From: Paul Cann <Paul.Cann@arun.gov.uk>
Sent: 14 October 2020 13:44
To: Planning.Responses <Planning.Responses@arun.gov.uk>
Subject: RE: Planning Consultation on: A/142/20/PL

Application No: A/142/20/PL

Site Address: Land North of Mayflower Way Mayflower Way Angmering BN16 4AY

Description of Works: Variation of condition 2-plans condition following A/46/19/PL to delete single garages to plots 1 to 4 and provide additional driveway parking instead.

STREET ELEVATION - SOUTH TO MAYFLOWER WAY - Plots 1 to 7.

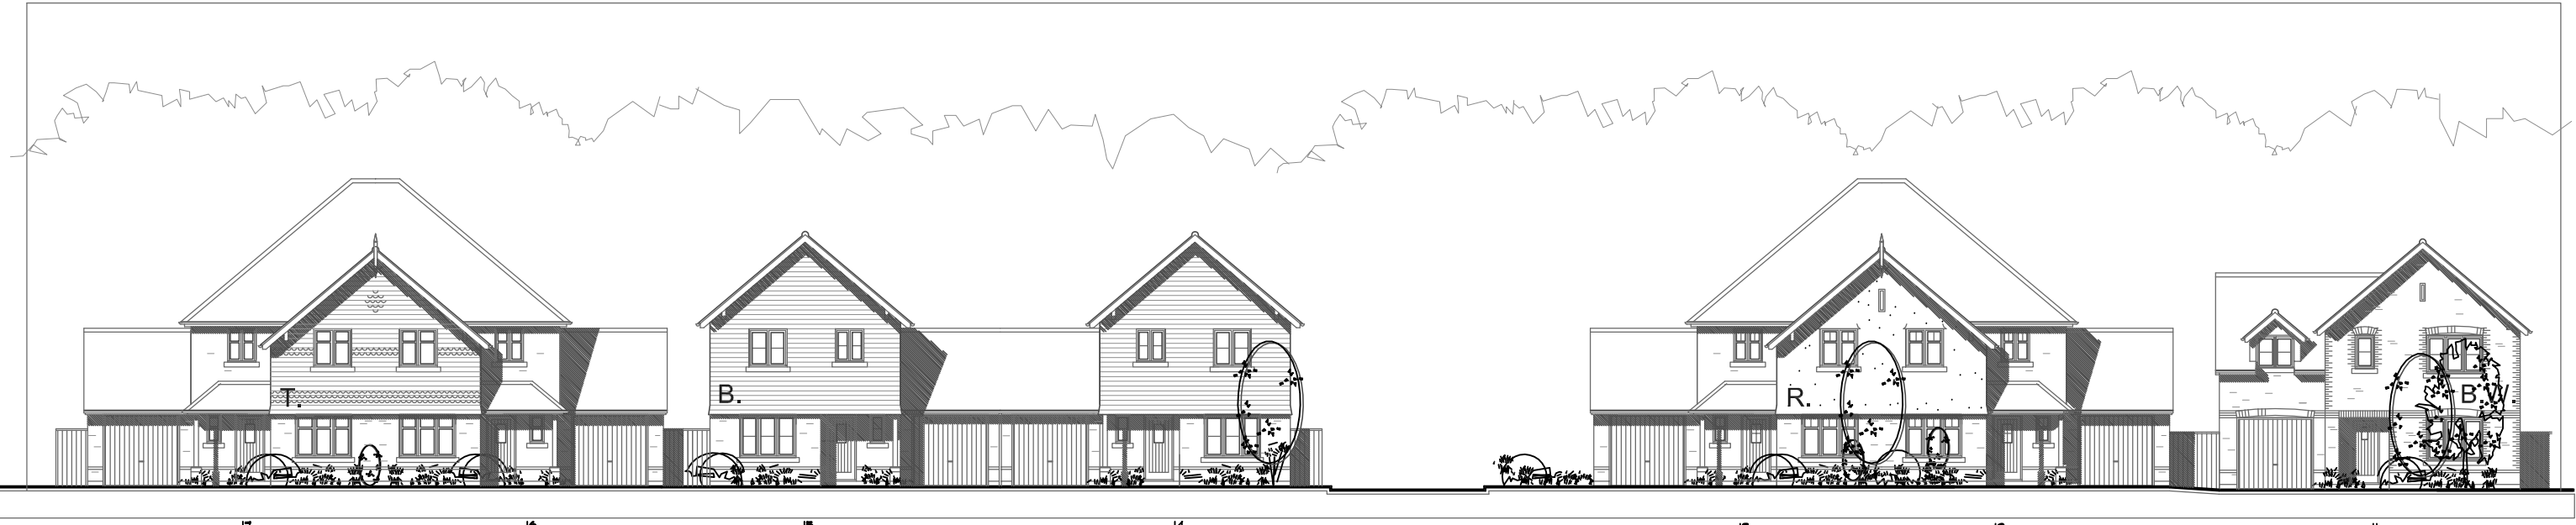
The replacement of plot 1 to 4 garages with car parking spaces, will mean that some minor alterations are required to the drainage design approved under A/34/20/DOC. Please also note that the car parking spaces should be constructed as permeable paving.

The applicant should submit revisions to the design for approval.
